From: Laura Gibbons <Laura.Gibbons@arun.gov.uk>
Sent: 14 February 2022 14:03
To: Planning.Responses <Planning.Responses@arun.gov.uk>
Cc: Obafemi Okusipe <Obafemi.Okusipe@arun.gov.uk>
Subject: RE: Planning Consultation on: LU/33/22/DOC

Engineers Comments Regarding Condition 11

Application No: LU/33/22/DOC

Site Address: Dutch Bicycle Company 46A & 46B Pier Road Littlehampton BN17 5LW

TITLE: Surface Water Drainage Strategy - Proposed Layout

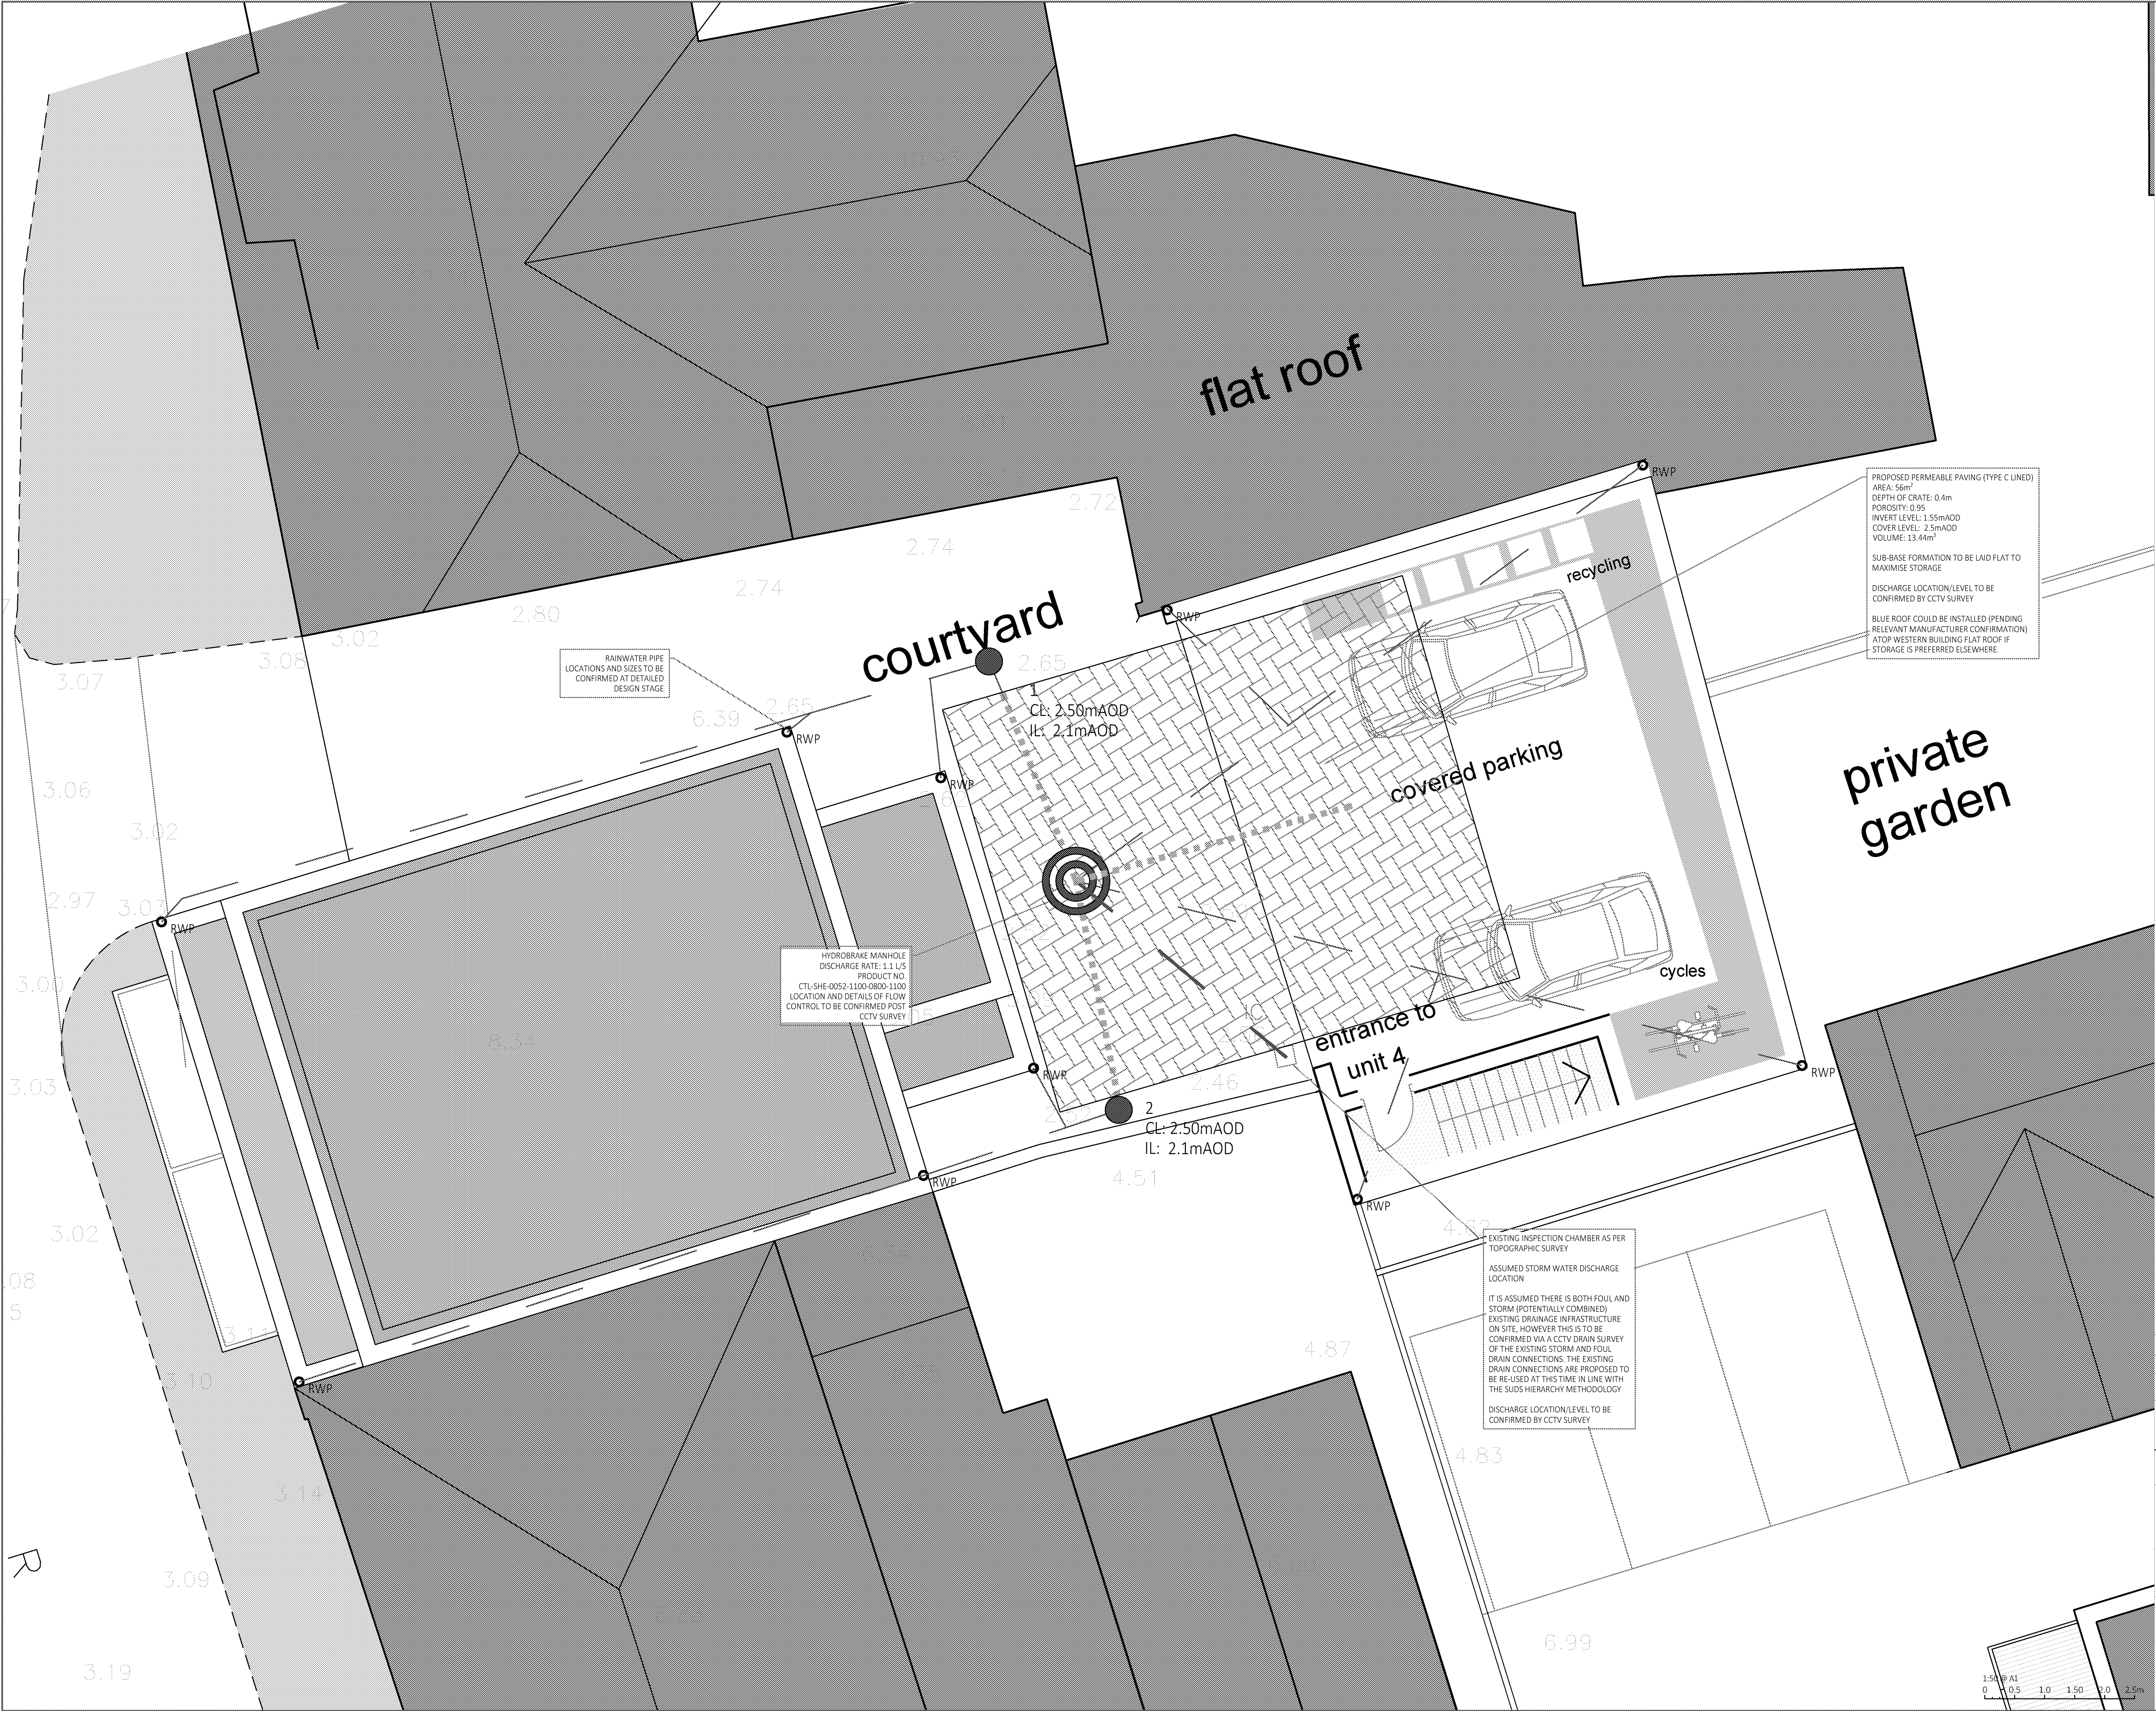
1. Please supply results from winter groundwater monitoring. This is required even where infiltration is not proposed to demonstrate that design resists flotation.
2. Catchpits must be provided upstream of connections into permeable paving sub-base/ attenuation crates.
3. Pipes must be labelled with pipe diameter and fall.
4. Details must show which drainage solution is proposed, not options.
5. Details of location of proposed connection to surface water sewer must be provided, including invert level.
6. Construction detail drawings must be provided.
